STATE OF NORTH CAROLINA  
DEPARTMENT OF TRANSPORTATION

STATE PROJECT: 40238.1.4 (U-4902D)  
F.A. NUMBER.: NHS-0017(76)  
COUNTY: New Hanover

DESCRIPTION: US 17 Business (Market Street) from Lendire Road to Marsh Oaks Drive

SUBJECT: Geotechnical Report Addendum – Rock Plating Recommendations

PROJECT REFERENCE NO.	SHEET NO.
U-4902D	10
RW SHEET NO.	U-4902CD-18
ROADWAY DESIGN ENGINEER	HYDRAULICS ENGINEER
<b>DOCUMENT NOT CONSIDERED FINAL UNLESS ALL SIGNATURES COMPLETED</b>

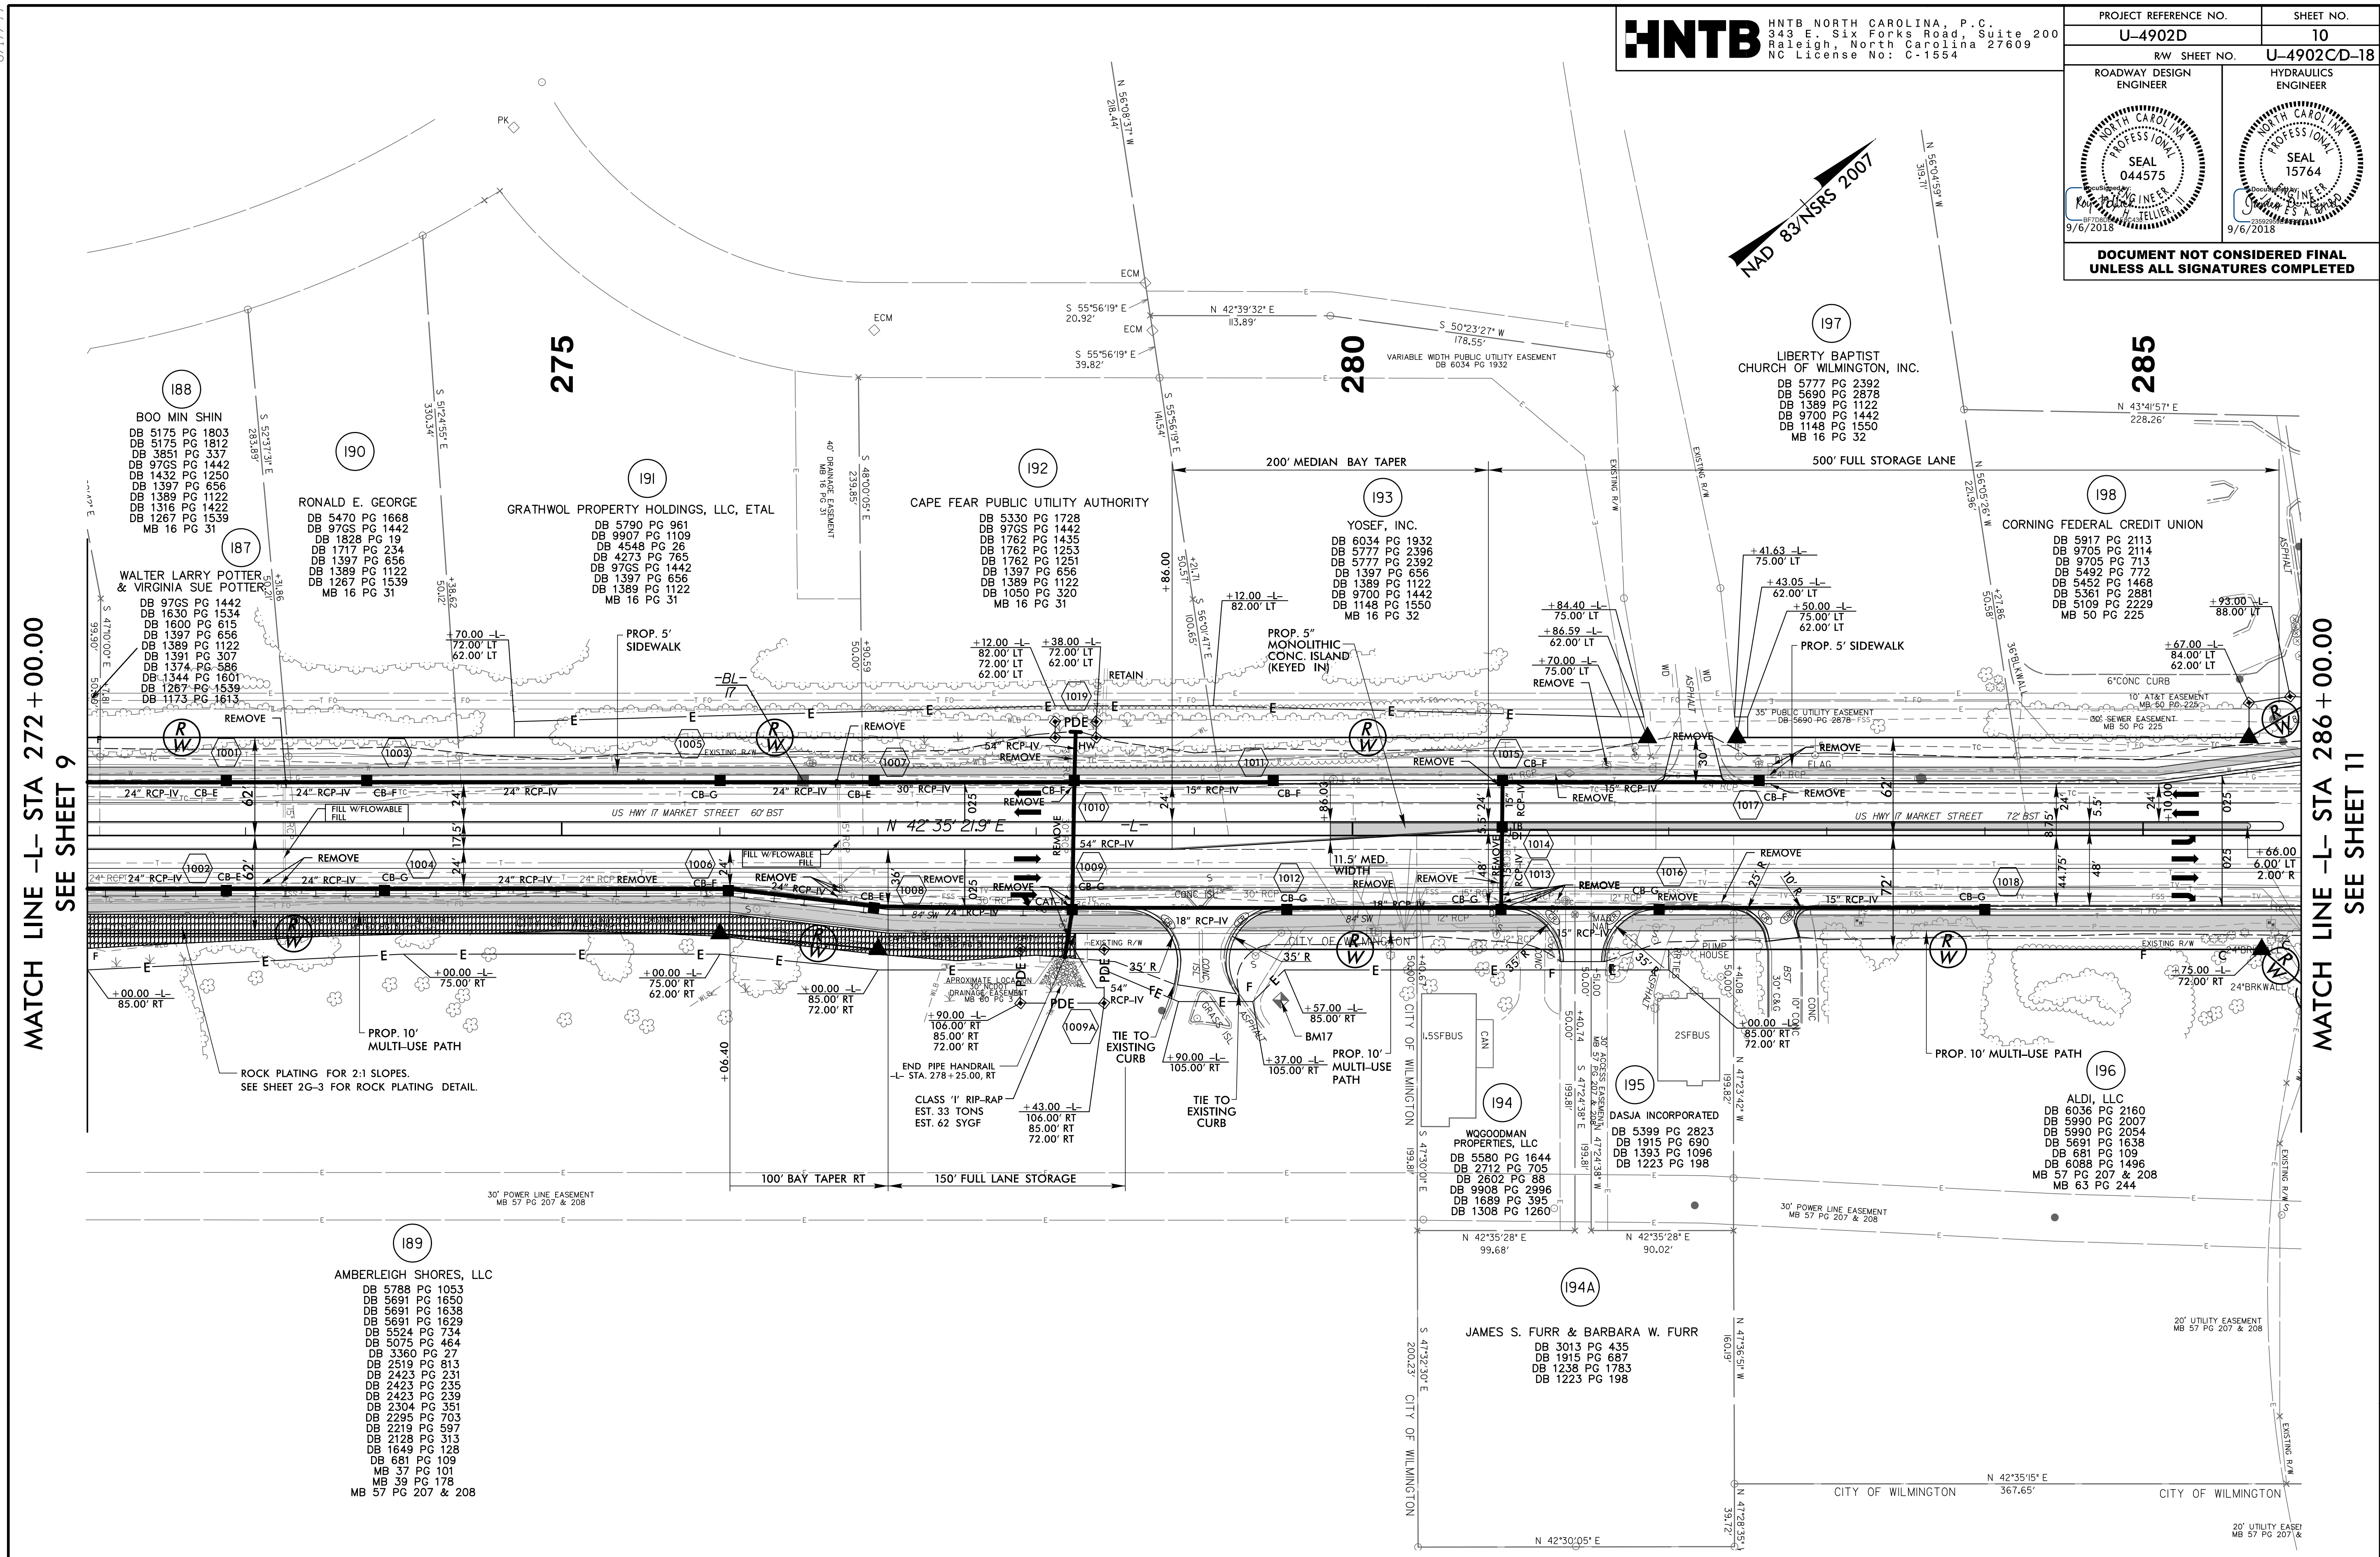
Per Division’s request, the Geotechnical Engineering Unit has reviewed the roadway plans and cross-sections for the proposed rock plated slopes listed below and provides the following recommendations.

<u>Line</u>	<u>Station(±)</u>	<u>Location</u>
-L-	270+75 ± to 278+75 ±	RT

Use the Standard Rock Plating detail No. 1 of the Standard Drawing No. 1802.01 as shown on the Roadway plans. The estimated quantity for rock plating is 1600 square yards. Rock Plating is outlined in the Section 275 of the 2012 Standard Specifications. The following note should be added to the Roadway Plans:

“USE ROCK PLATING DETAIL NO. 1 AT -L- STA 270+75± TO -L- STA 278+75±, RIGHT. EXTEND ROCK PLATING LIMITS TO 2.75:1 (H:V) SLOPES. SEE STANDARD ROCK PLATING DETAIL.”
